Application for a non-material amendment following a grant of planning permission.
Town and Country Planning Act 1990

FIRST FLOOR EXTENSION OVER EXISTING GARAGE
CONVERSION OF GARAGE TO HABITABLE ROOMS.
CONVERSION OF CONSERVATORY INCLUDING PITCHED ROOF

BN/19/19/4H

FIRST FLOOR OVER GARAGE :- STANDARD WINDOW TO FRONT [SOUTH]
ELEVATION IN LIEU OF DORTIER.

Drg. no. 1828/02 Rev.
X

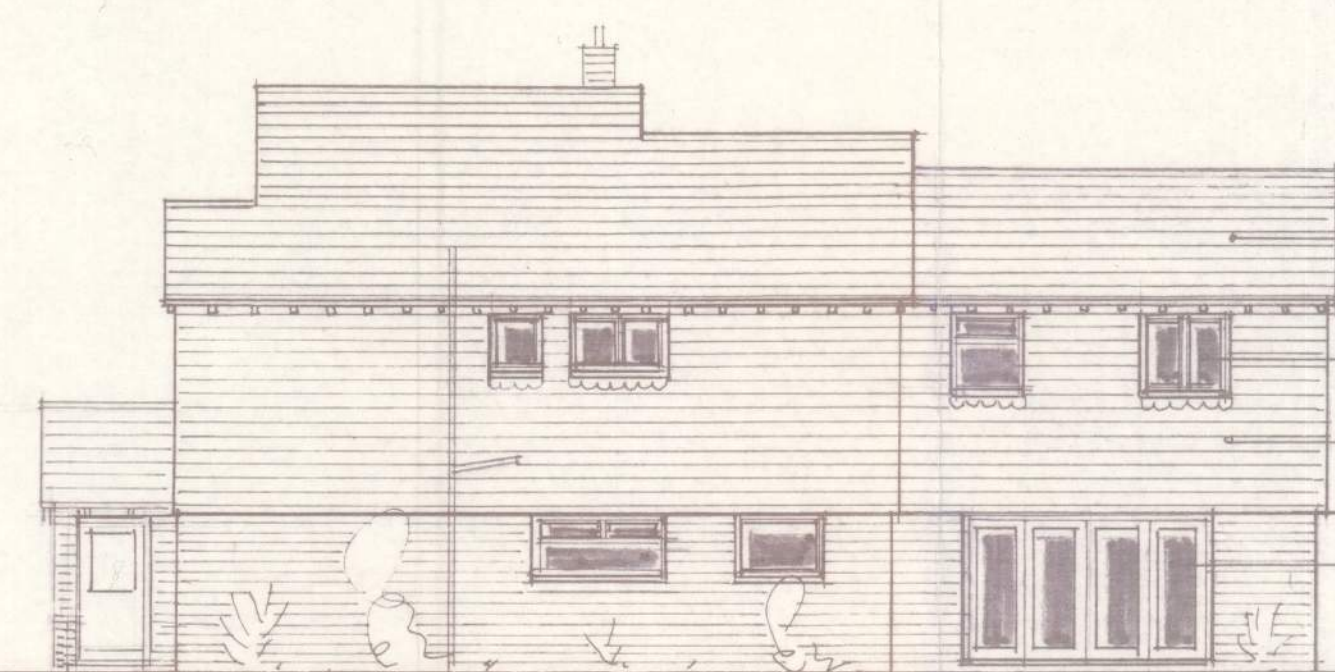
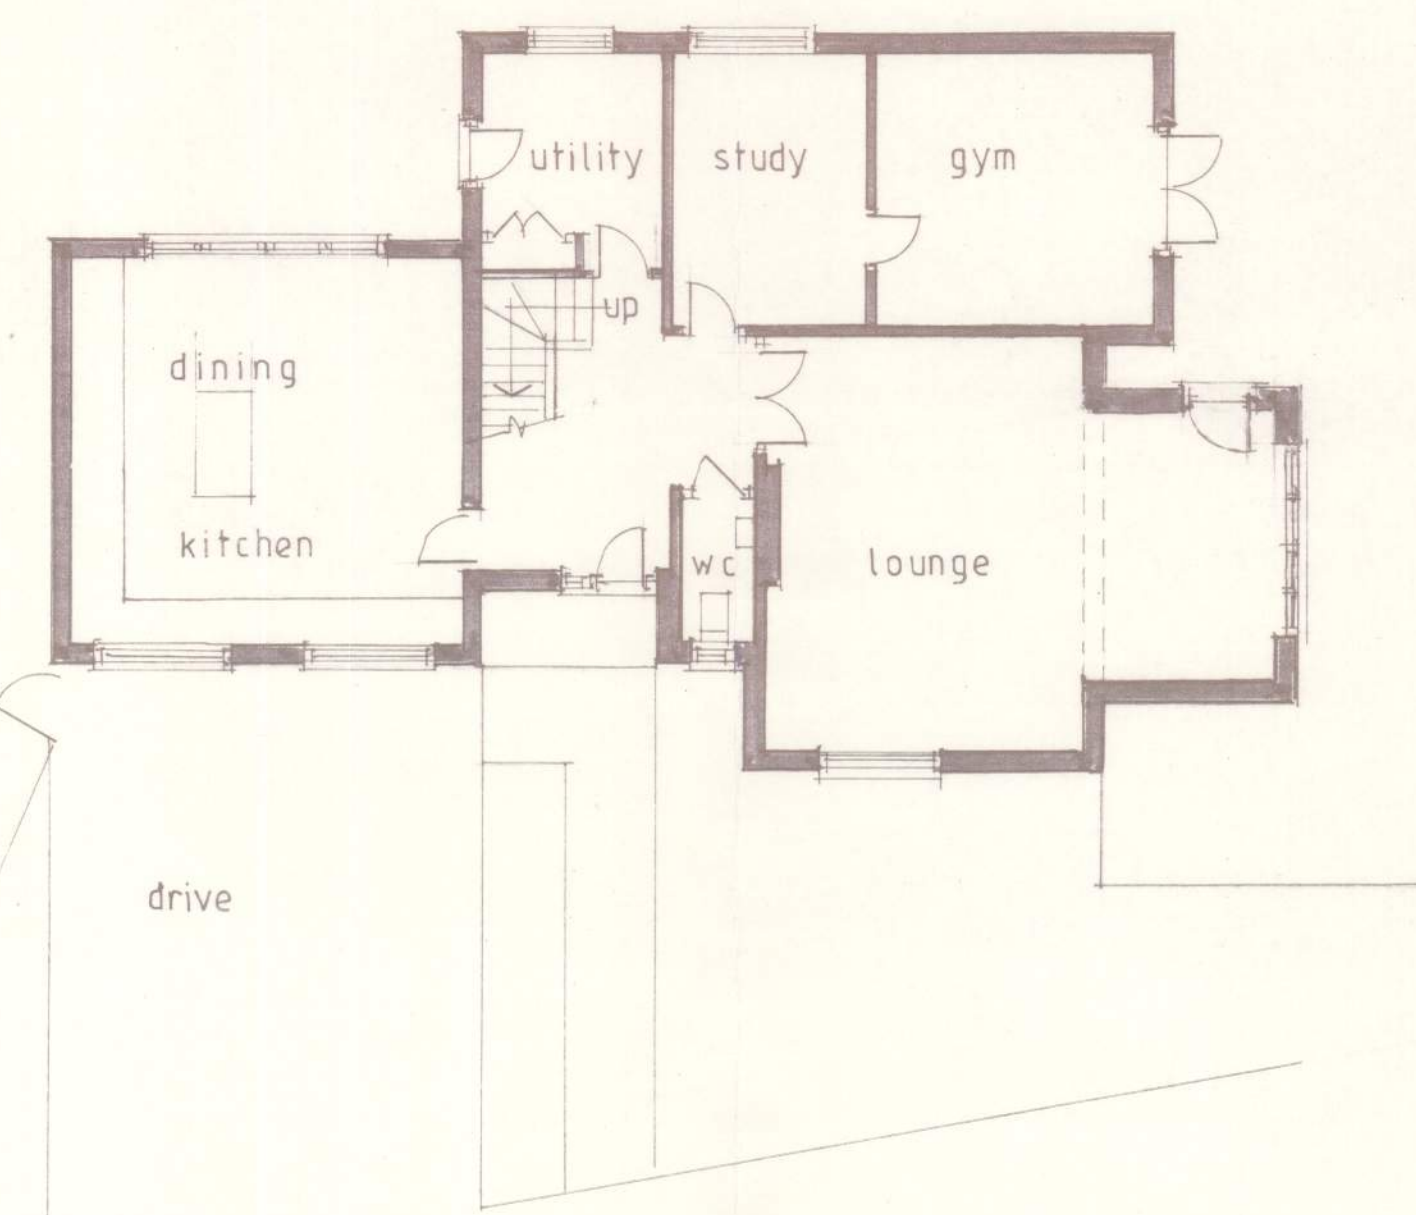
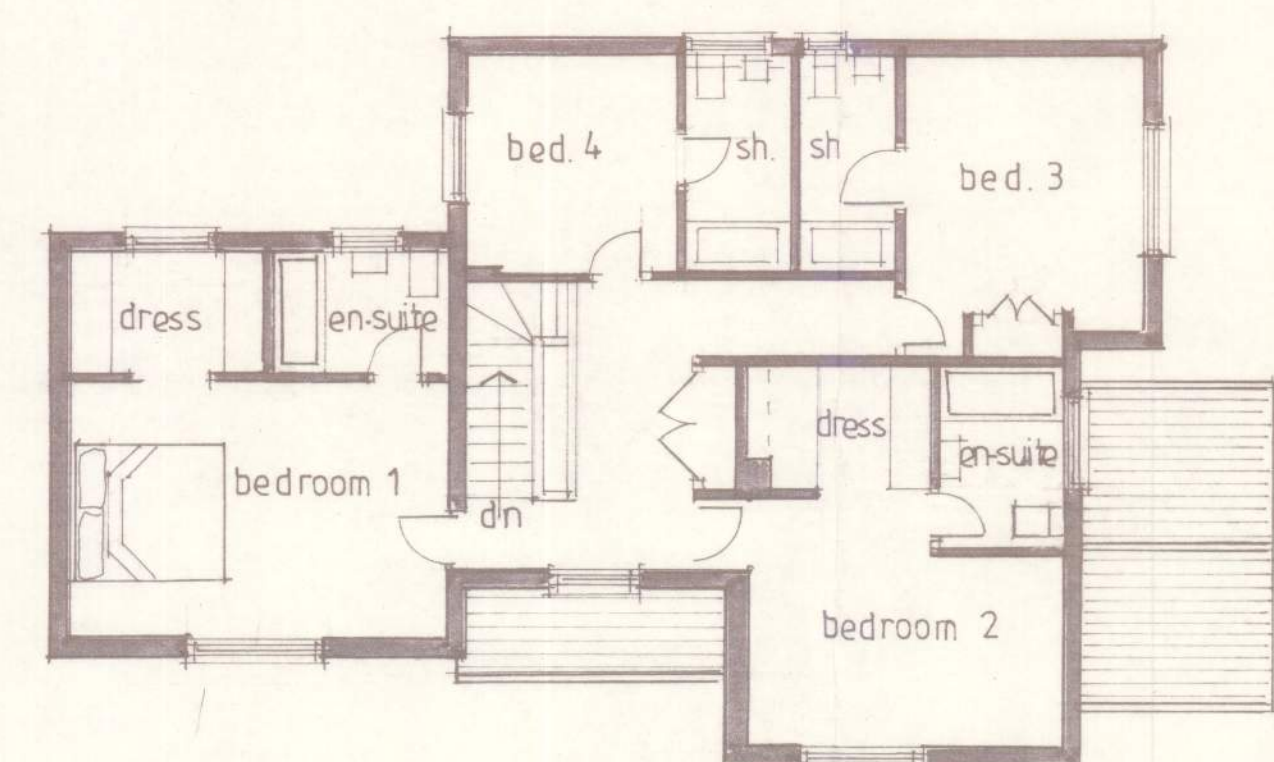
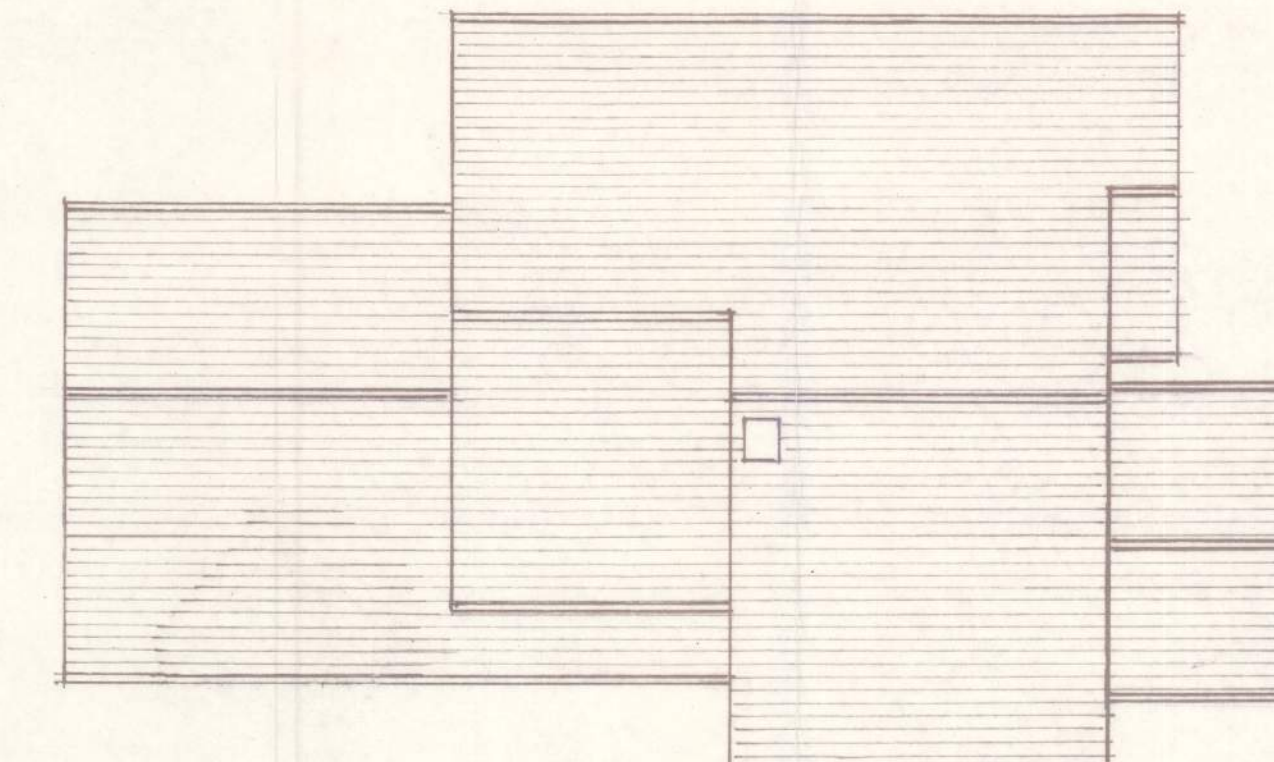
CONVERSION OF CONSERVATORY:- REDUCTION TO WINDOW AREA.
